From: Paul Troop [REDACTED]
Sent: 02 January 2024 06:02
To: Suzanne Taylor; Planning; White, Joy - Oxfordshire County Council; JacquiCox (OCC); Plater, Roger - Oxfordshire County Council
Cc: chair@bicesterbug.org
Subject: Applications 23/00170/REM, 23/00214/REM (Himley Village)
Importance: High

Thank you for giving us the opportunity to comment on these applications. Though these are details of two junctions, we have two key concerns:

TITLE MIDDLETON STONEY ROAD, MAIN SPINE ROAD JUNCTION. GENERAL ARRANGEMENT SHEET 1	
HYDROCK PROJECT NO. C-27141-C	SCALE @ A2 1 : 500
STATUS DESCRIPTION INFORMATION	STATUS S2
DRAWING NO. (PROJECT CODE-ORIGINATOR-ZONE-LEVEL-TYPE-ROLE-NUMBER) 27141-HYD-XX-XX-DR-D-0001	REVISION P02

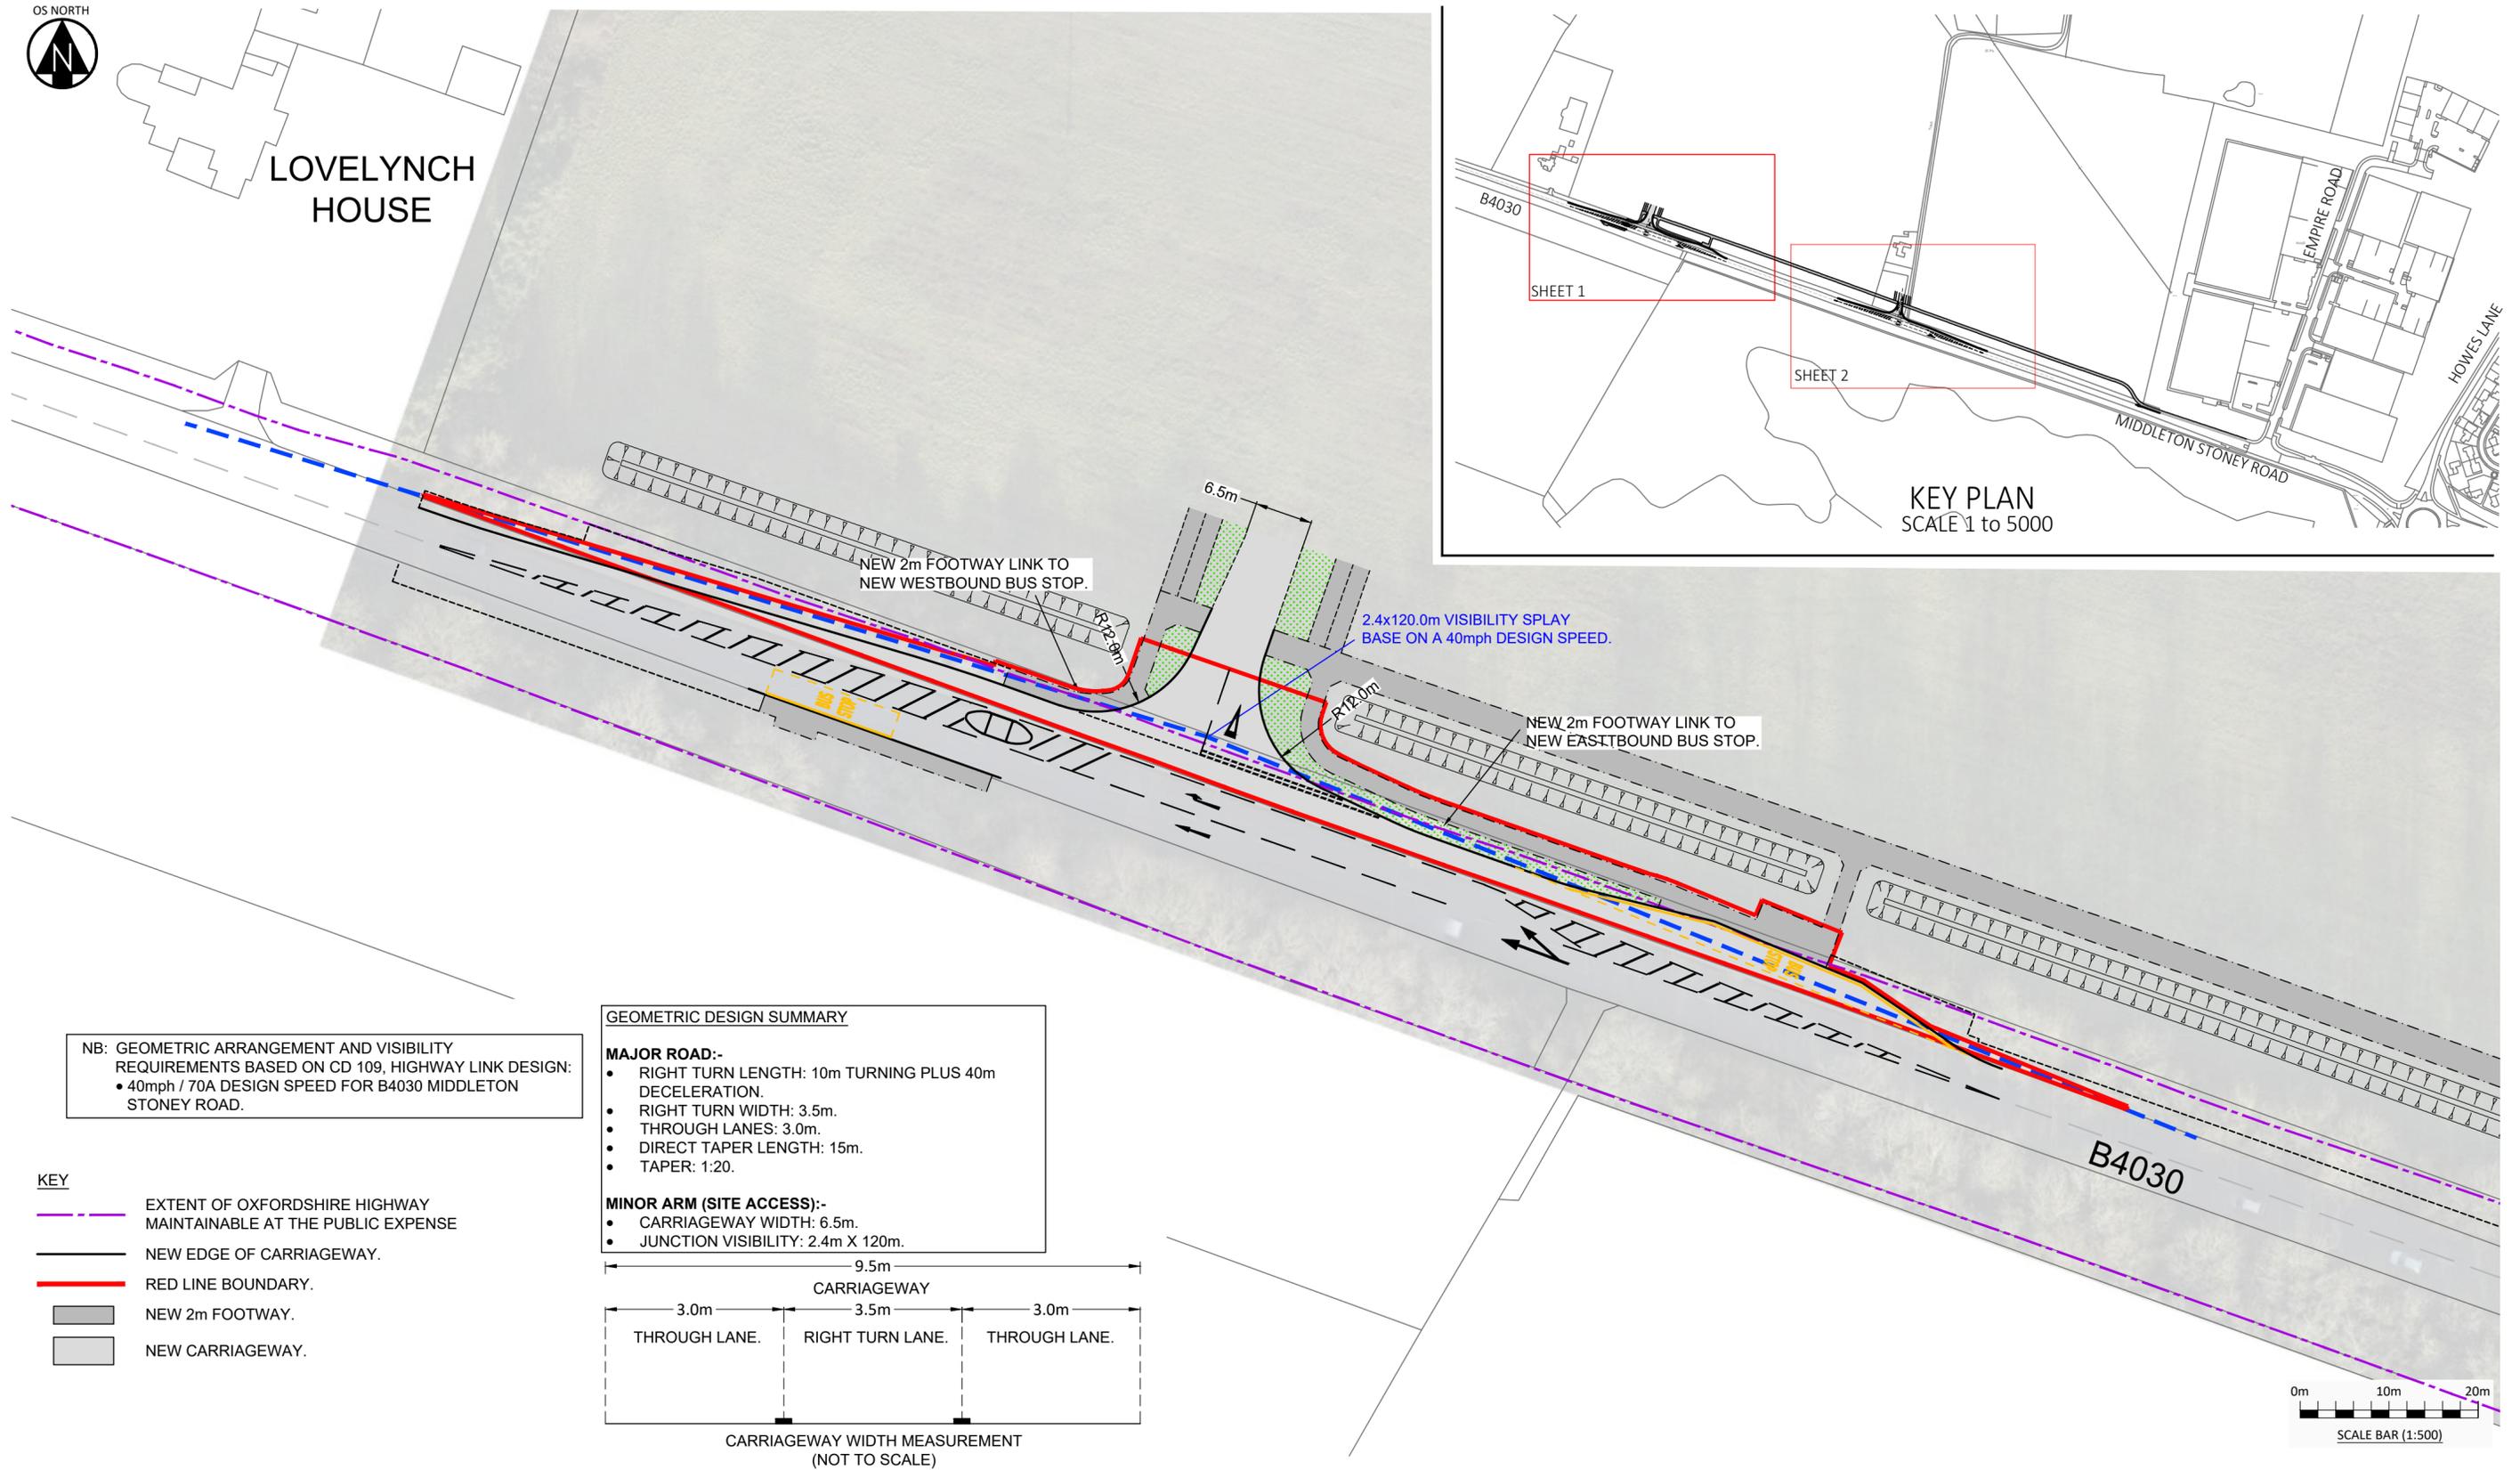
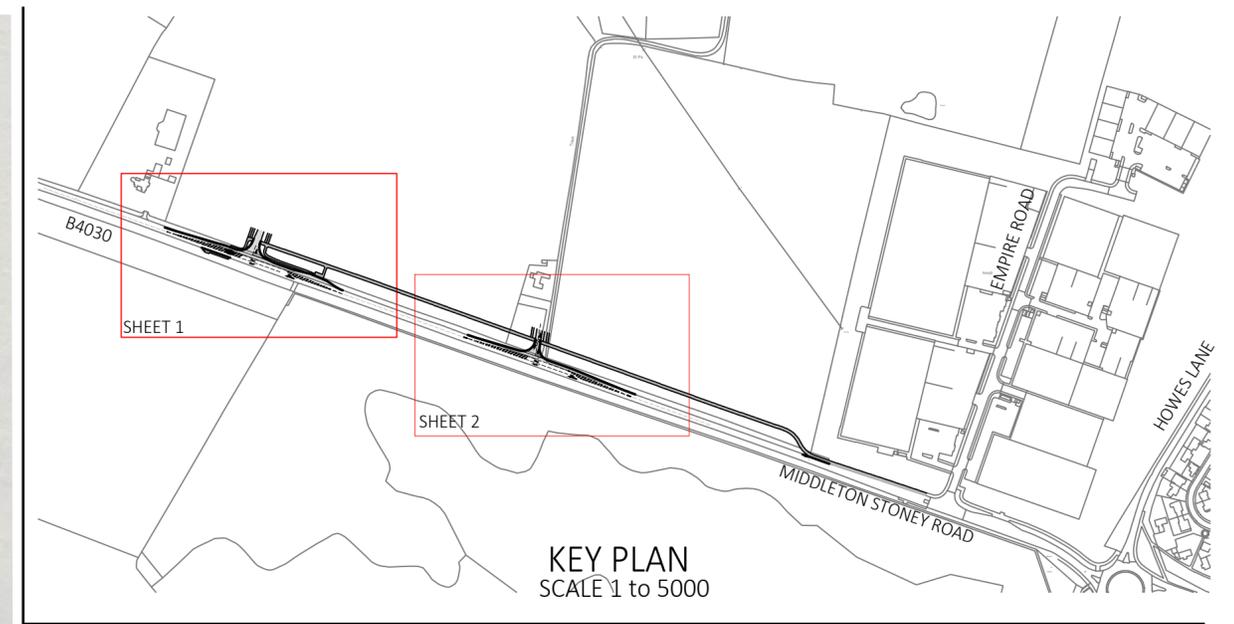
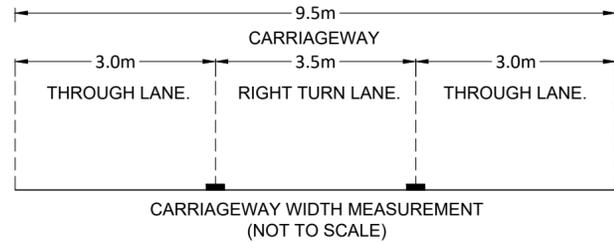
- We are concerned that the junctions envisage a cycle path on only one side of the spine road. This is not in compliance with the OCC Cycling Design Standards which require cycle paths on both sides of a spine road [2.2.6]. It is also poor practice, making it difficult for cyclists starting or ending their journey on the 'wrong' side of the spine road to access the cycle path. The junctions should make provision for cycle paths on both sides of the spine road.
- At present there are uncontrolled crossings for pedestrians and cyclists at these two junction locations, meaning that pedestrians and cyclists will not have priority. The crossings should be amended to provide priority for these modes of transport, such as by the use of a raised table, road markings, or preferably a parallel crossing.
